# DN03486D

**CS\_CUCHARES\_RANCH GENERATOR ADD**  
**DN03486D BU#: 823518**  
 9285 DRENNEN ROAD  
 COLORADO SPRINGS, CO 80925  
 LATITUDE: 38°46'48.55" N  
 LONGITUDE: 104°39'20.17" W

MODIFICATION OF AN EXISTING "NON-INHABITABLE" T-MOBILE TELECOMMUNICATIONS SITE:  
 -INSTALL (1) RD048 DIESEL GENERATOR  
 -INSTALL (N) CONCRETE PAD  
 -INSTALL (N) AUTOMATIC TRANSFER SWITCH  
 -ADD REQUIRED LEASE AREA (40 S.F.)

# Elevation Plans\_v1.pdf Markup Summary

TITLE SHEET

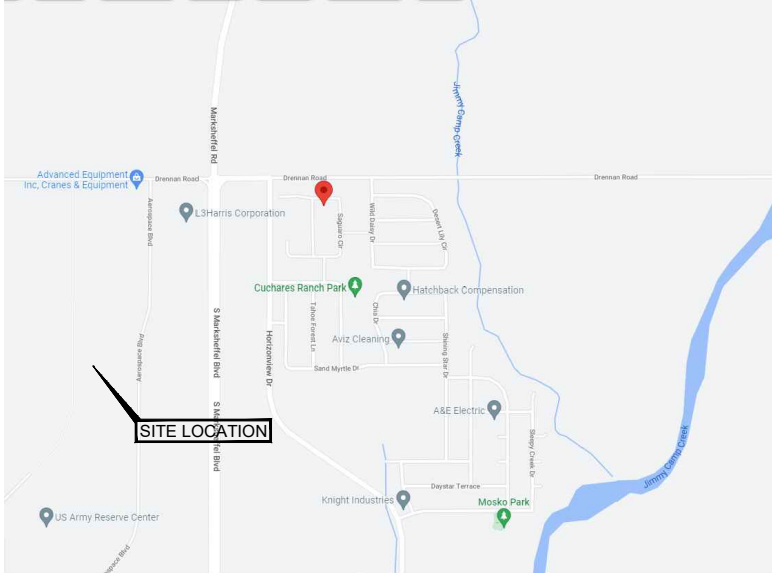
Please include:  
-legal description of the property  
(can be found on assessor website)  
-lot/parcel size

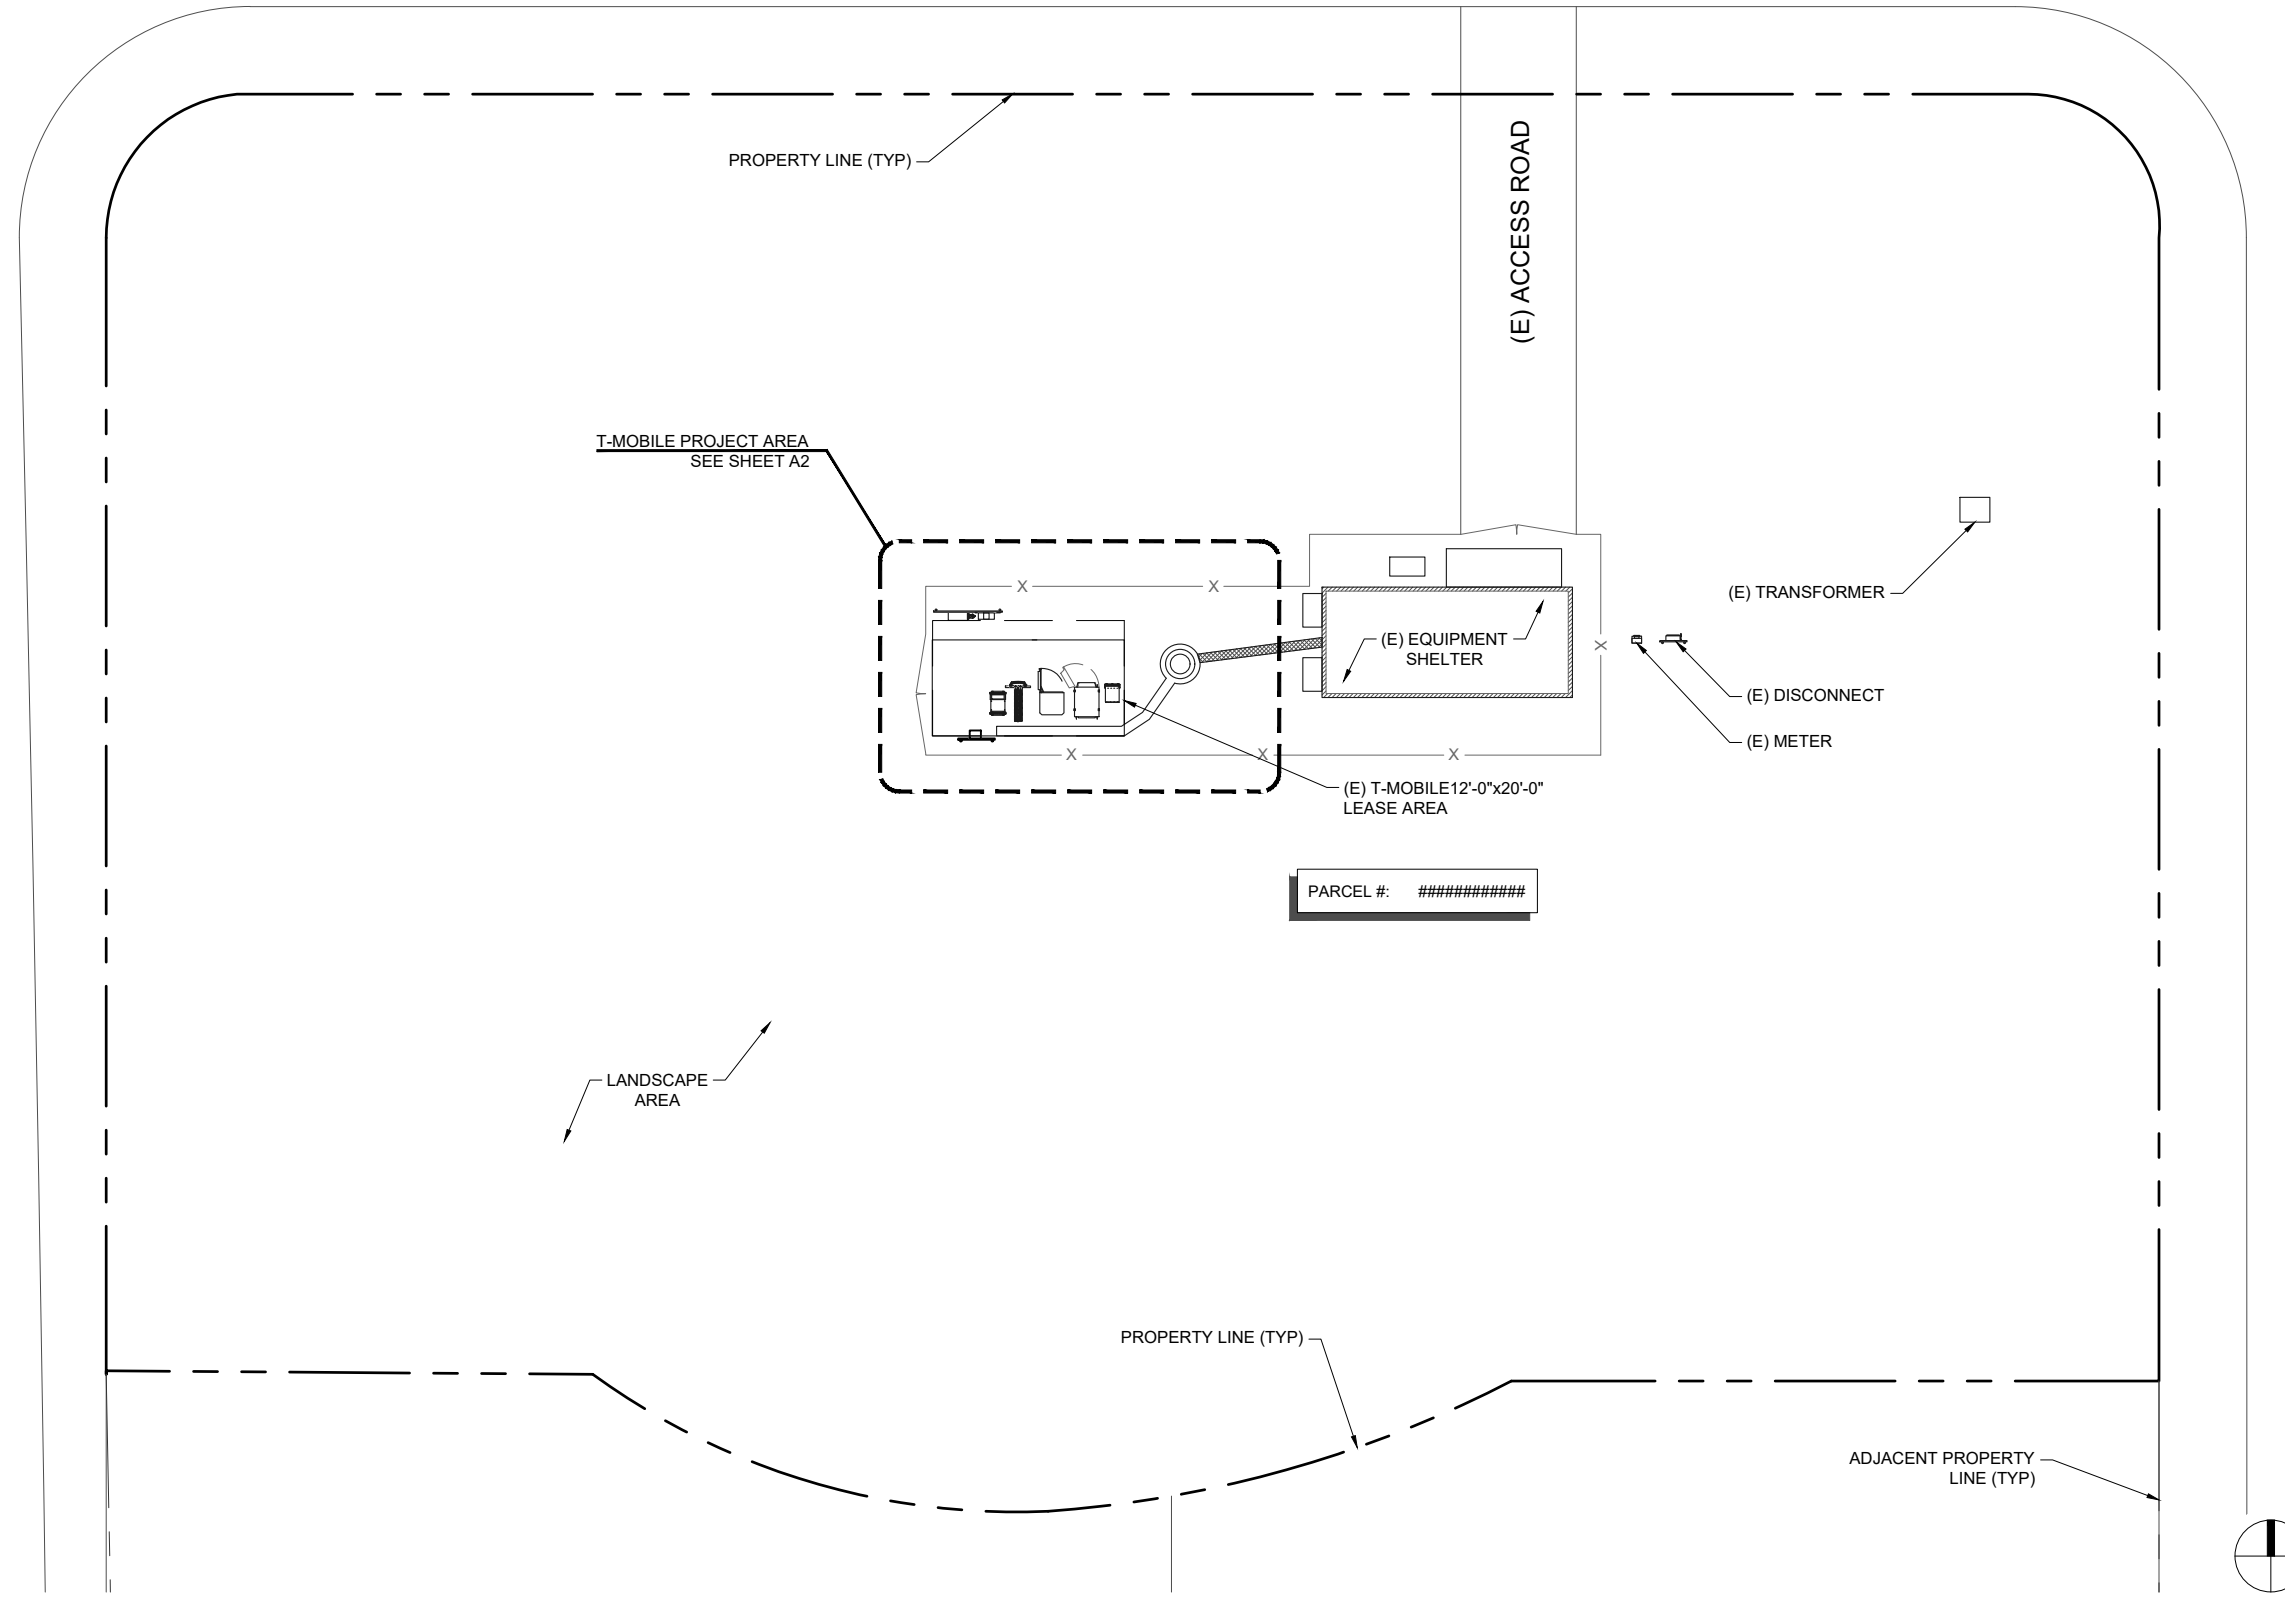
Please include:  
-dimensions of property lines  
-location and dimensions of right of way and all  
existing and proposed easements  
-the footprint of all existing and proposed buildings  
and the setback distances from each existing and  
proposed structure to property lines
